Application for a Non-Material Amendment Following a Grant of Planning Permission

Enlarged west side dormer and two storey east side extension

23/P/00144

Minor alteration to the north west corner of the proposed west side extended dormer.

Client	Drs K & G Hampshire	Date	Sept '22
Project	Proposed Alterations to Christmas Pie House Normandy	Drawn	JGR
		Scale	1:100@A2
Title	As proposed Plans & Elevations	Drwg. No	2207/05H

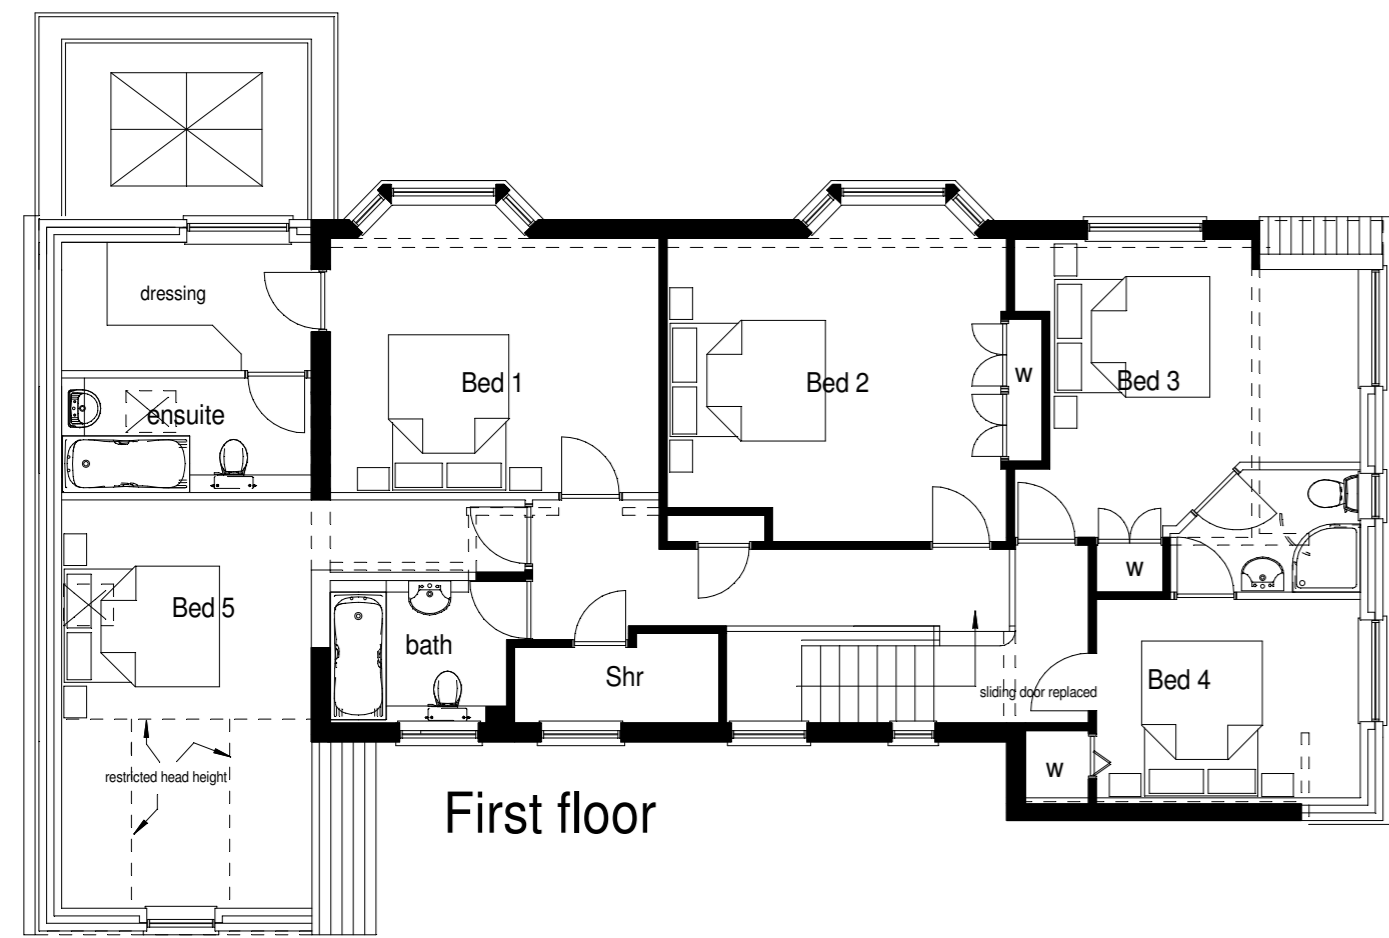
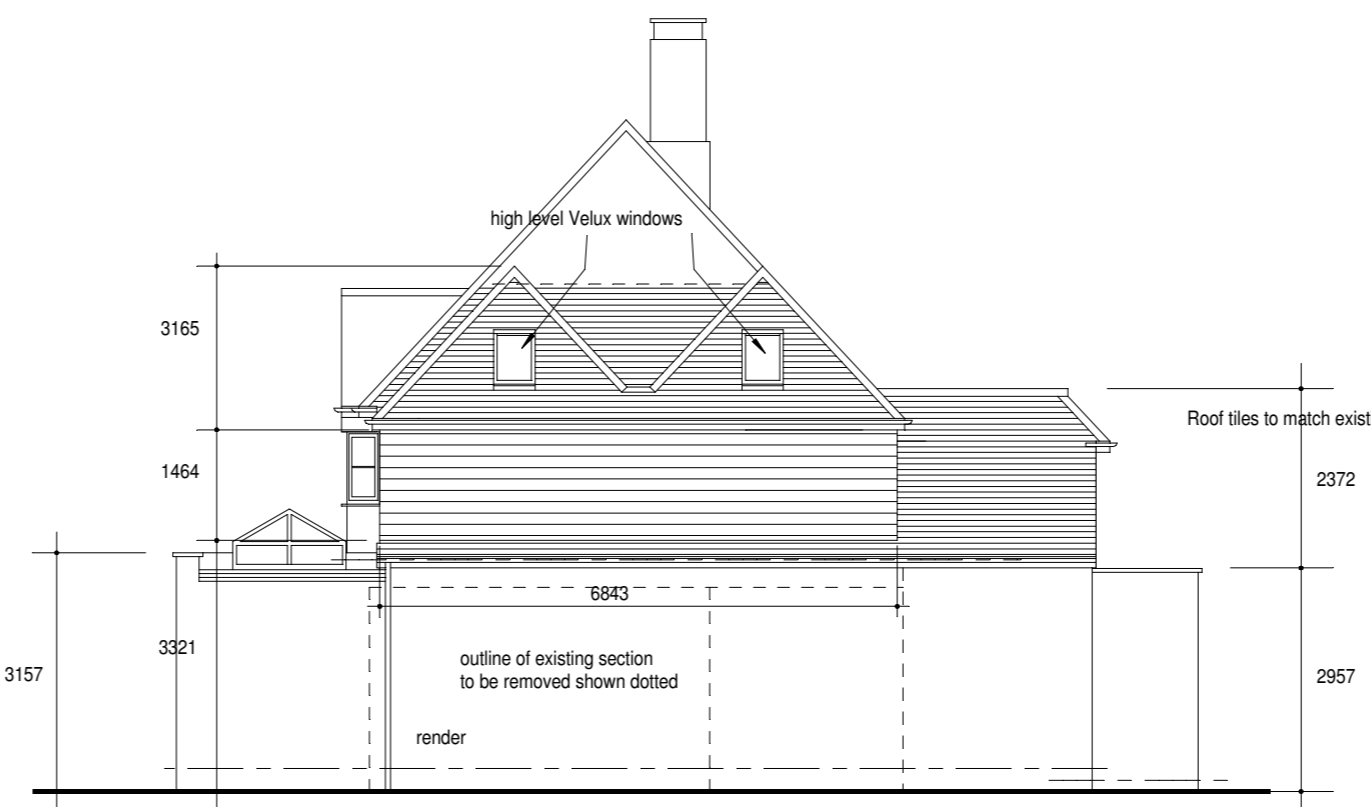
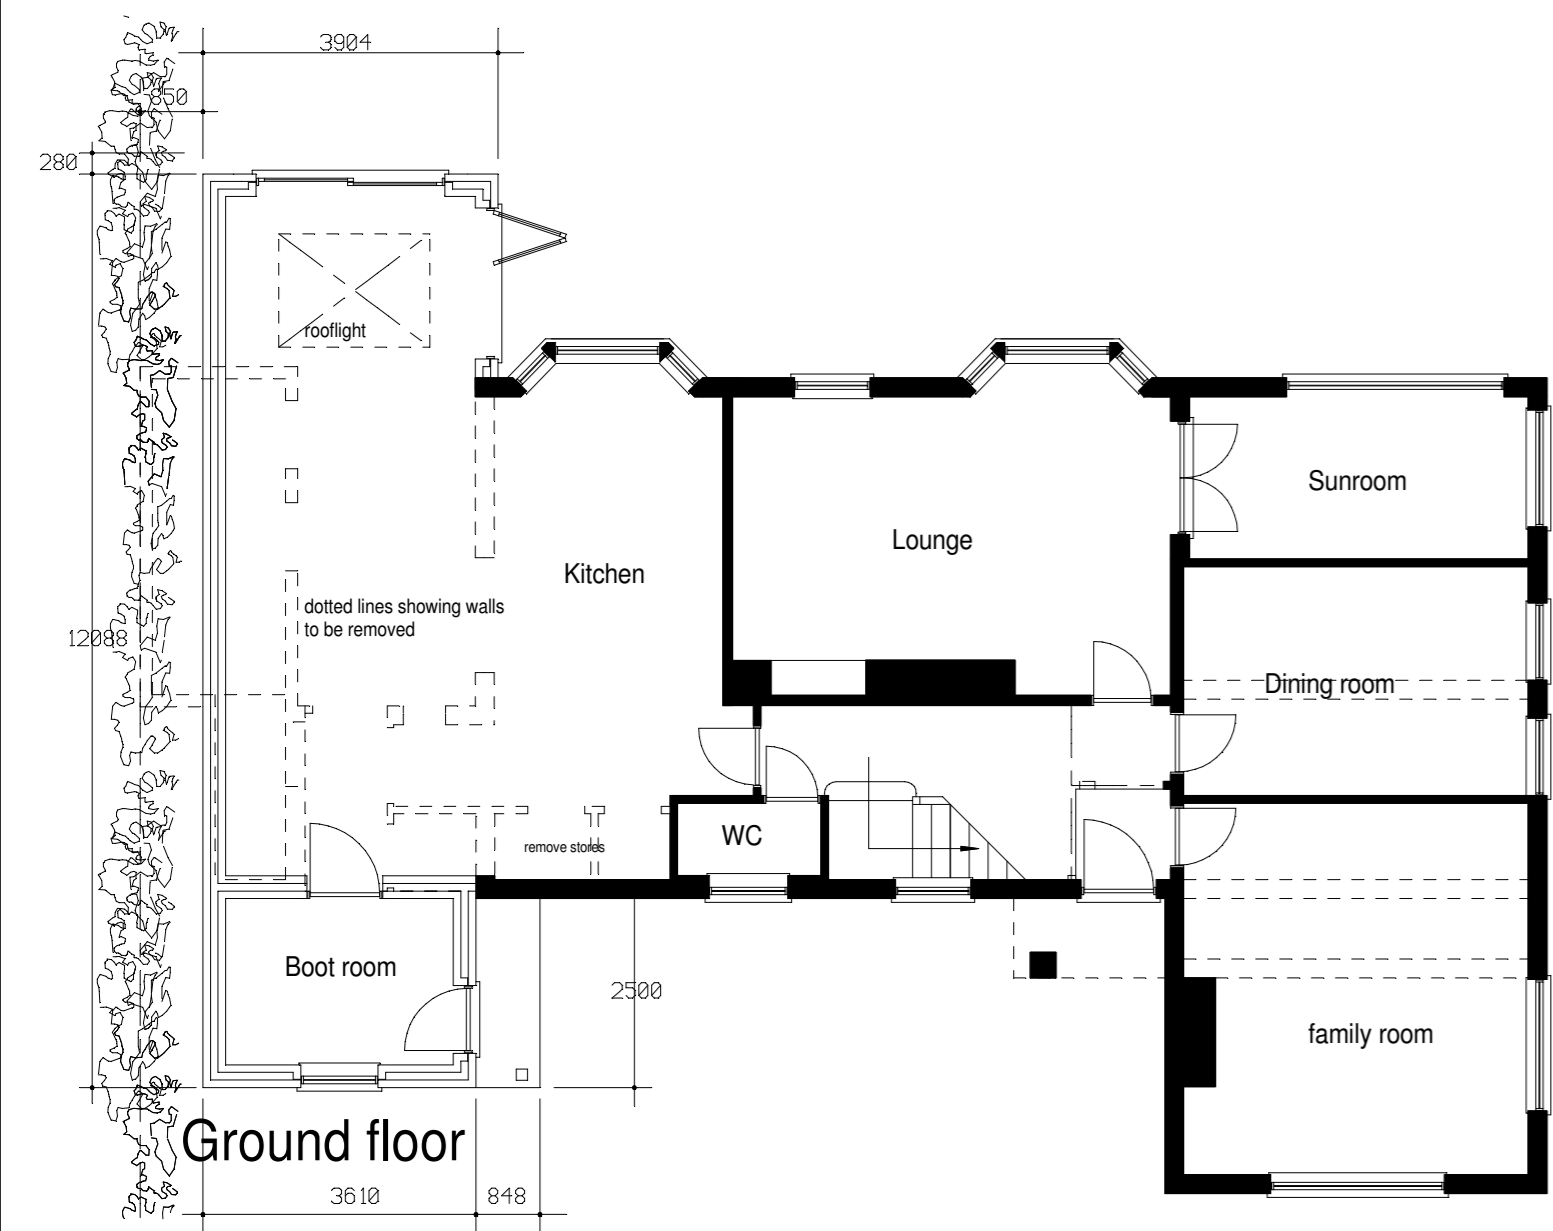
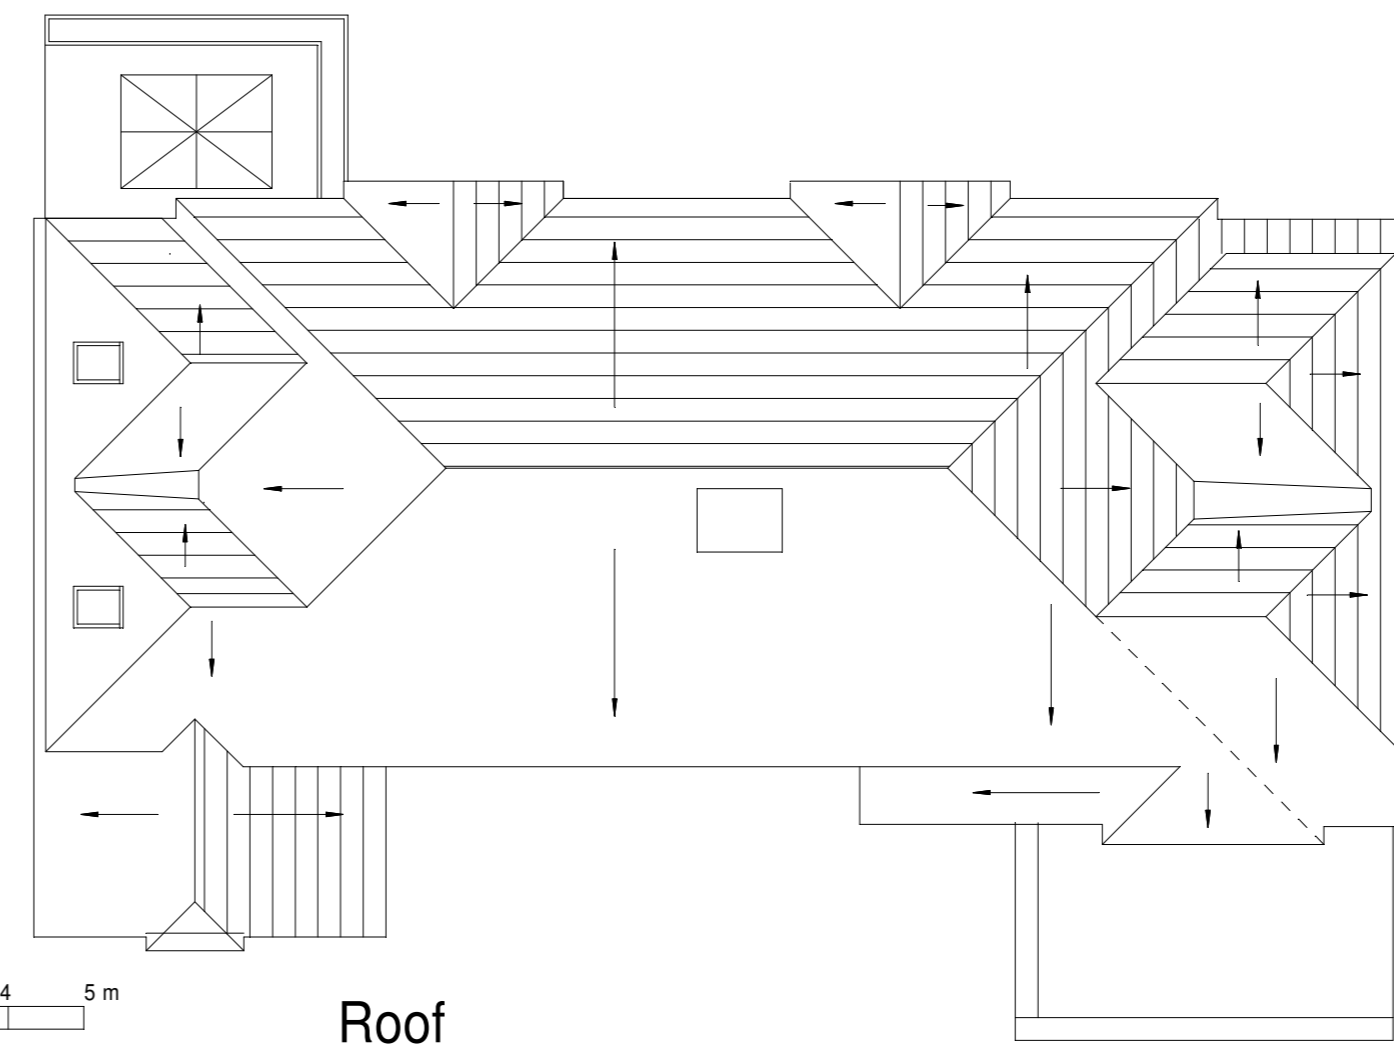
The revision to this corner of the dormer will improve the appearance of the new dormer when seen from the front (road) elevation and make the construction simpler. The changes to the mass, bulk, and height will not not alter the height, scale and overall extent of its visual perception.

2207/05H
